# CITY OF ALBUQUERQUE

**Re: A & S Autocare**  
4900 2<sup>nd</sup> St. NW Albuquerque NM 87120  
**Traffic Circulation Layout**  
Engineer's/Architect's Stamp **04-19-2019** (F15D054)

Based upon the information provided in your submittal received 04-22-19, the above referenced plan cannot be approved for Building Permit until the following comments are addressed:

HC PAVEMENT MARKING

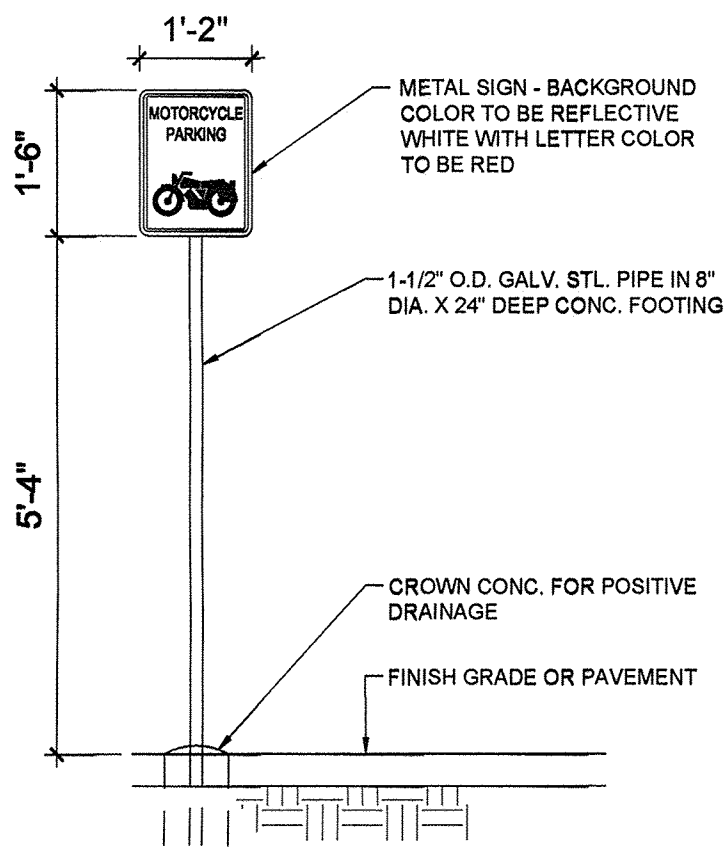
4. The ADA access aisles shall have the words **"NO PARKING"** in capital letters, each of which shall be at least one foot high and at least two inches wide, **placed at the rear of the parking space so as to be close to where an adjacent vehicle's rear tire would be placed.** (66-1-4.1.B NMSA 1978) Please consider moving the "No Parking" inside the stippled area.

SITE PLAN

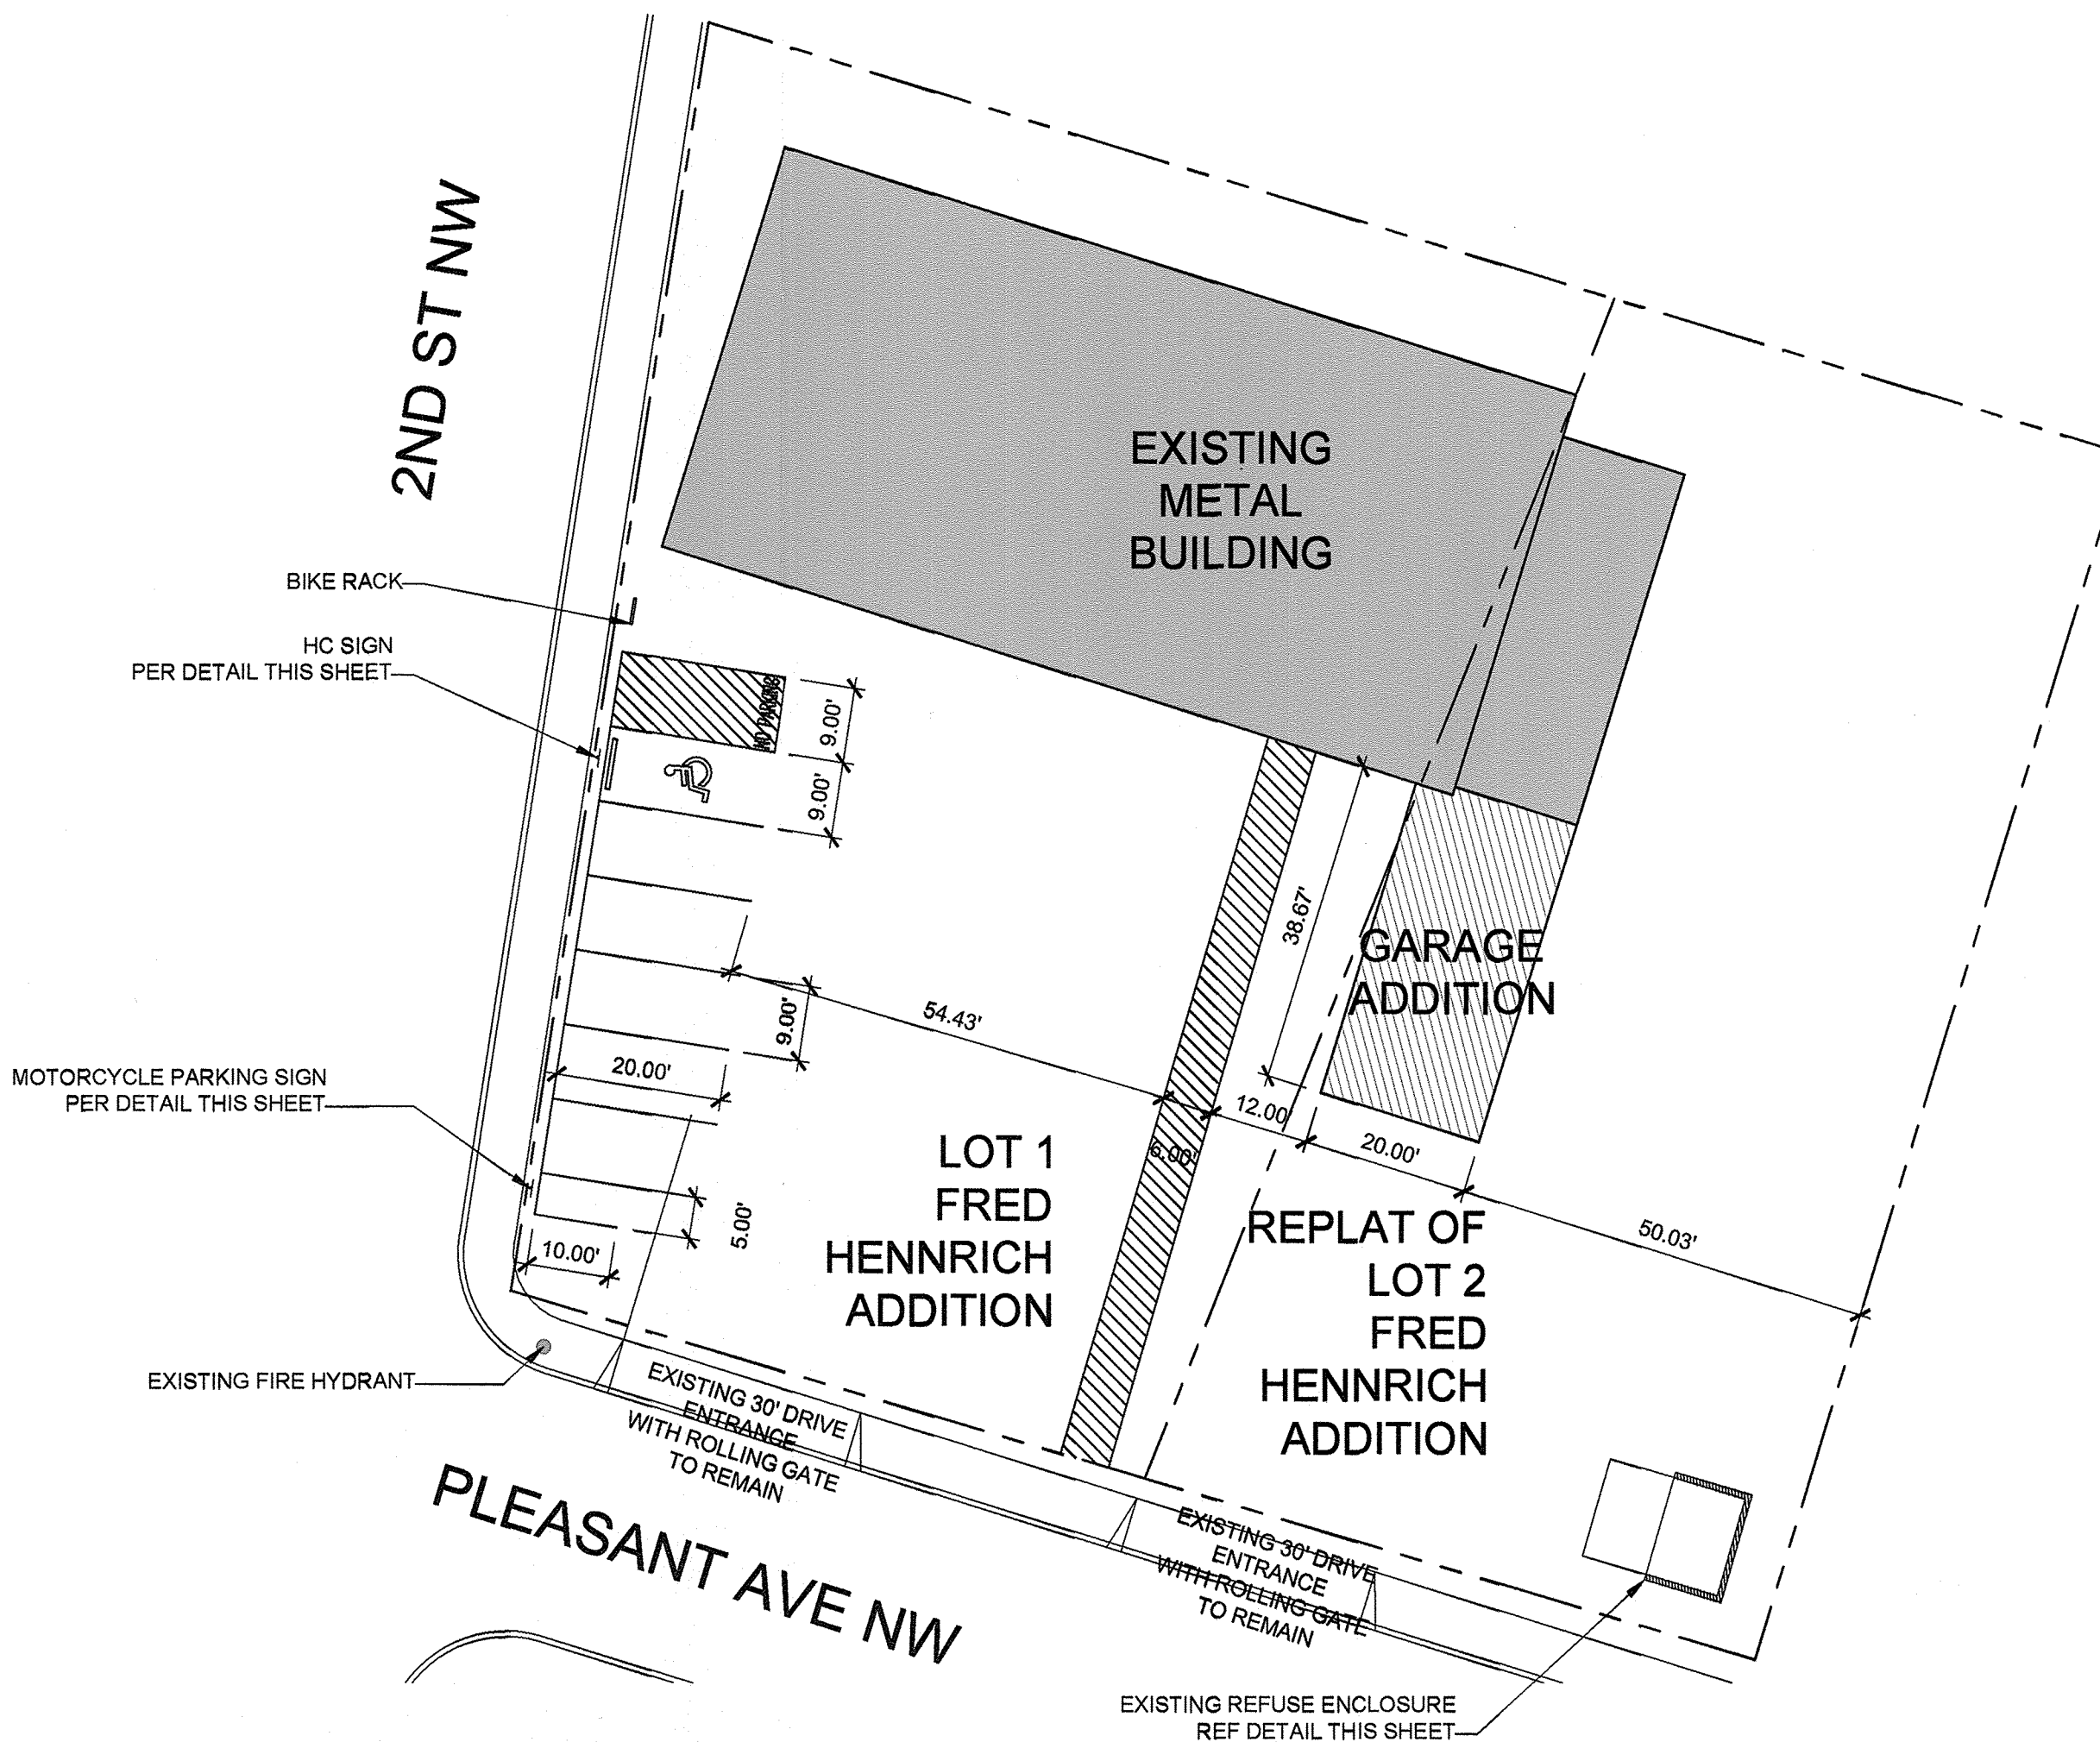
1. The property line shown is different than what is shown on AGIS Map. Has there been a recent replat?
2. The handicap accessible spaces must be a minimum of 8.5 ft. in width. Please show the dimension.

3. The handicap accessible spaces must include an access aisle. Van accessible aisles should be 8ft wide; all others should be 5ft wide. Please show the dimension.

5. Per the IDO, a 6 ft. wide ADA accessible pedestrian pathway is required from the public sidewalk to the building entrances. Please clearly show this pathway and provide details. The pathway shown is inside the driveway. Either change the entrance width to 25 ft or move the pathway to the west.
